Comment from Greenspace

APPLICATION NO: P/20/18/DOC

Site Address: 7 Webb Close Pagham PO21 4XB

Description of Works: Approval of details reserved by conditions imposed under P/107/16/PL relating to conditions 3-surface water drainage, 4-schedule

PROPOSED
SITE PLAN

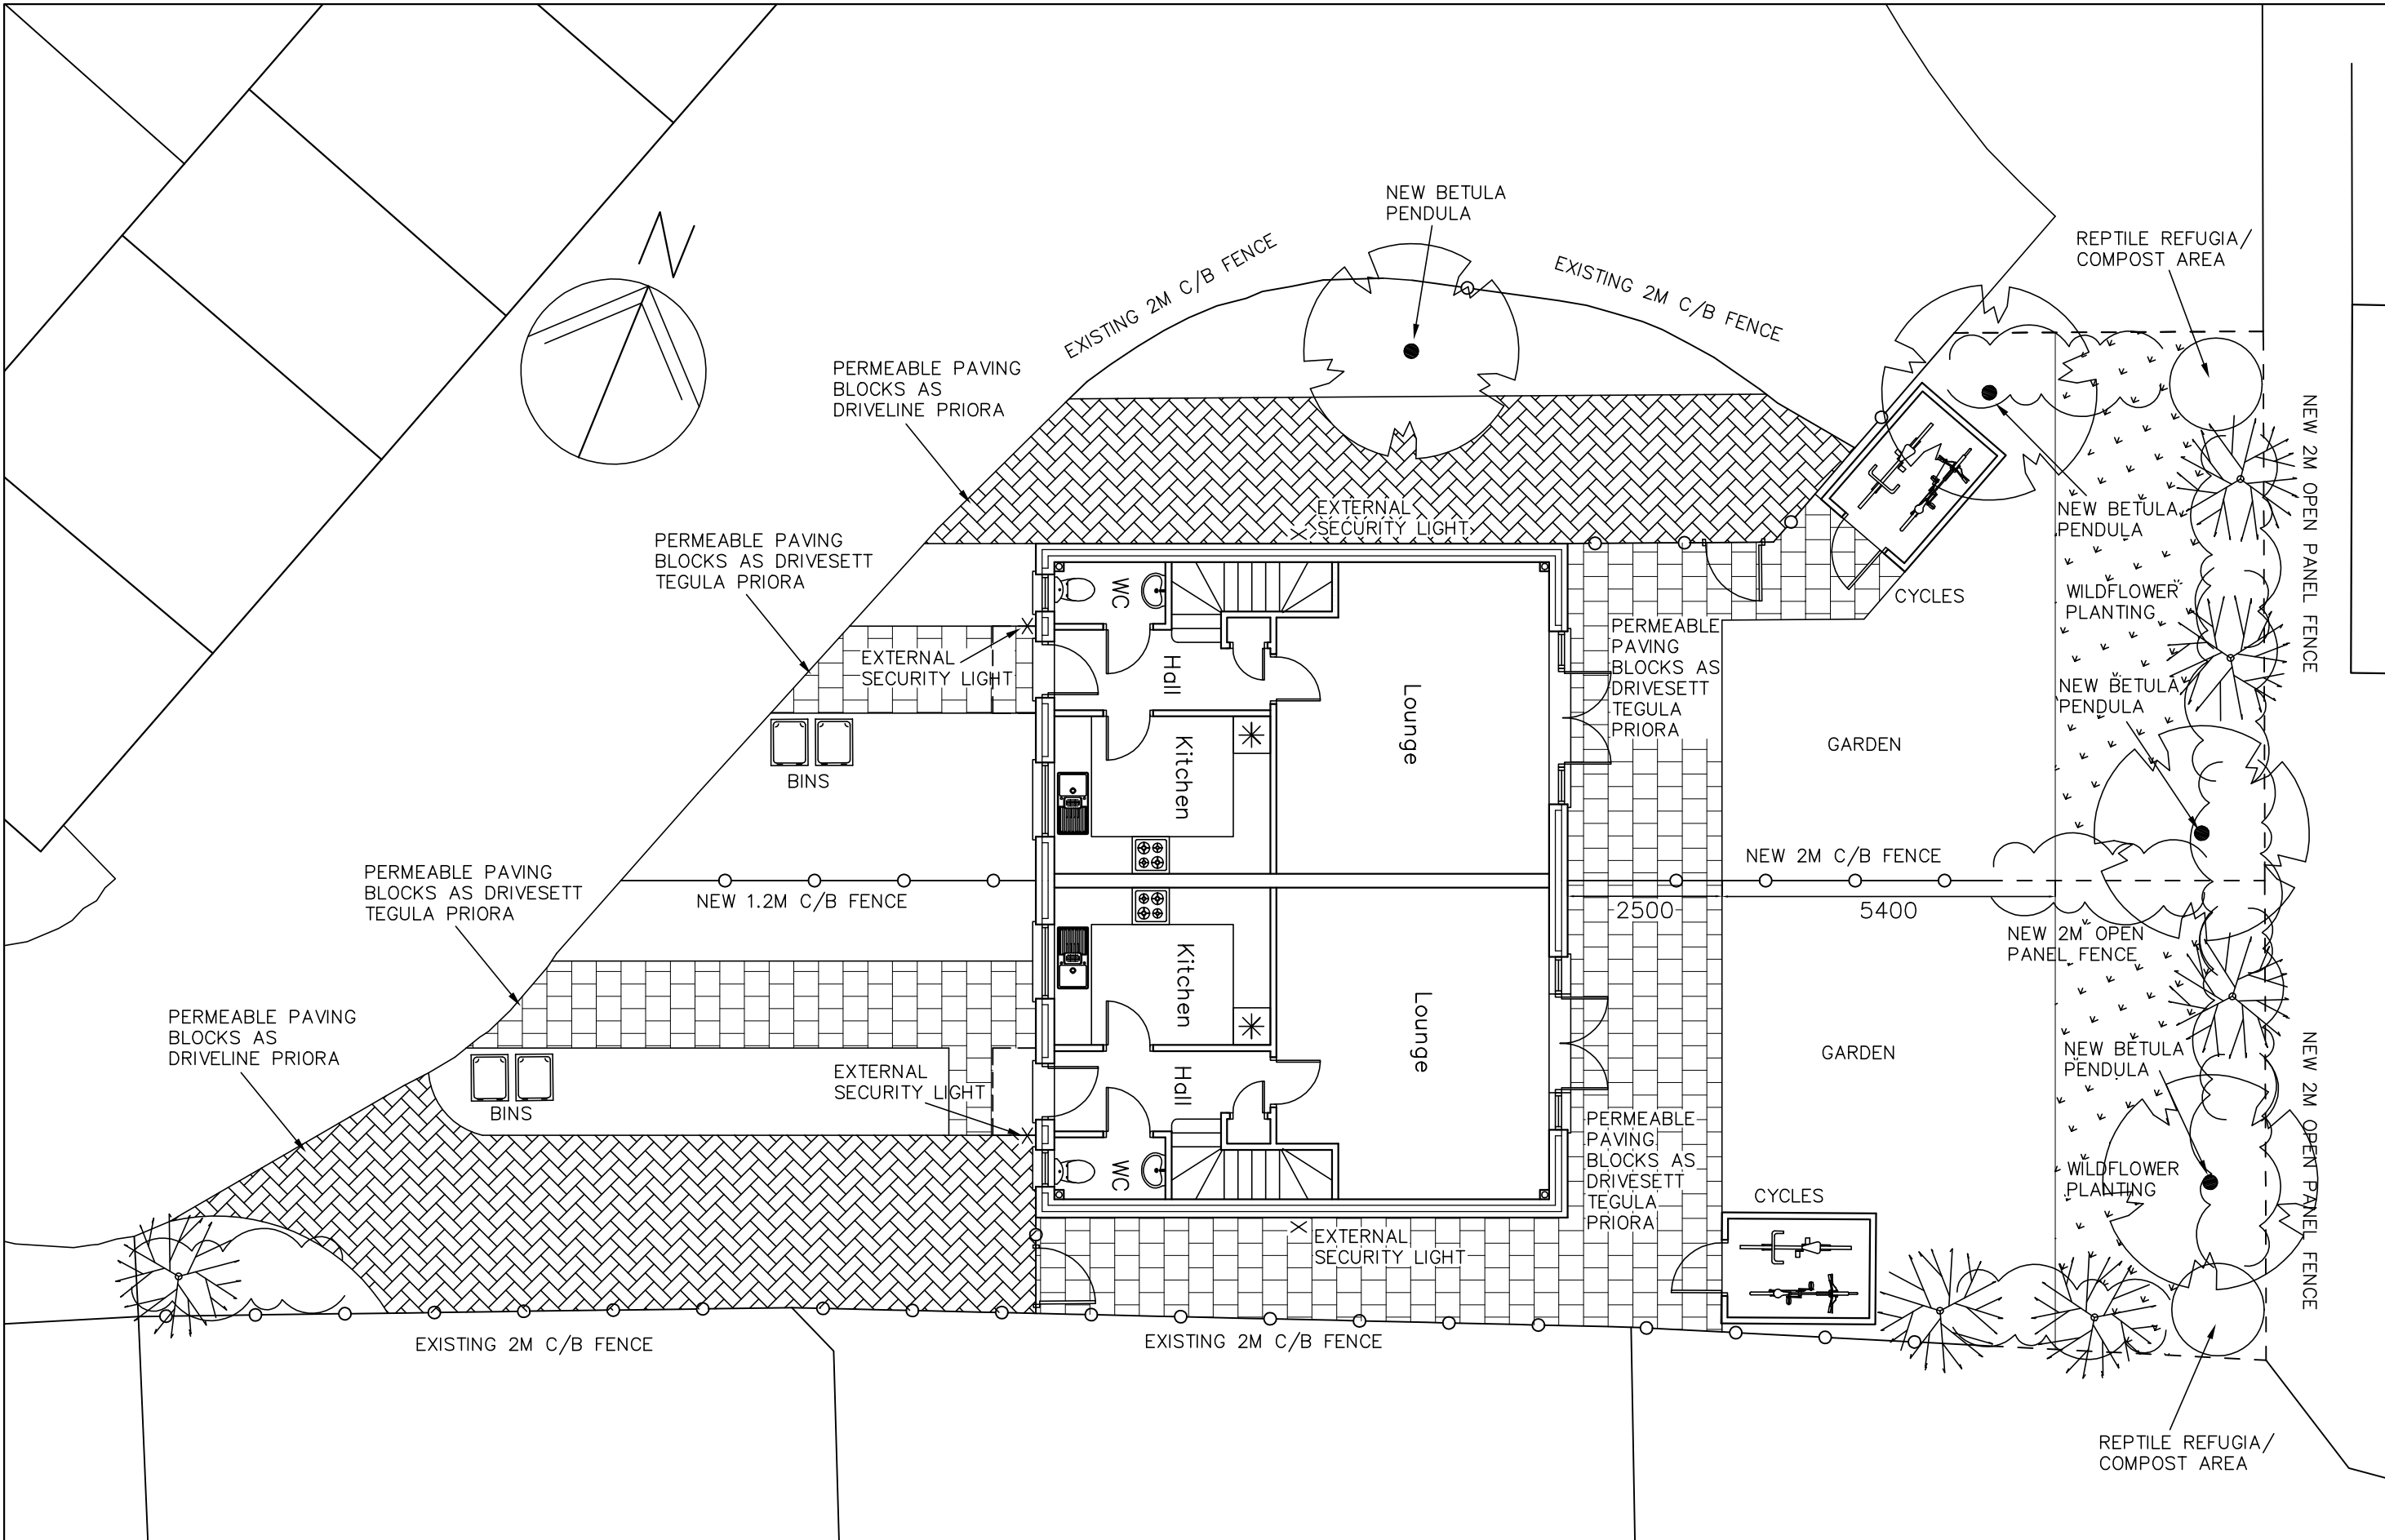
Drawings submitted under application P/20/18/DOC and additional Planning Statement Feb 2018 propose a suitable landscape scheme and provide good detail regarding species choice being proposed, however these drawings need to detail actual numbers being proposed for the hedging species rather than just planting densities plus the size at time of planting for the hedging and trees. We would **request that this information is submitted for approval** therefore we would **not recommend the discharge of Condition 5 landscaping** on application AP/20/18/DOC imposed under P/107/16/PL until this additional information is submitted and approved.
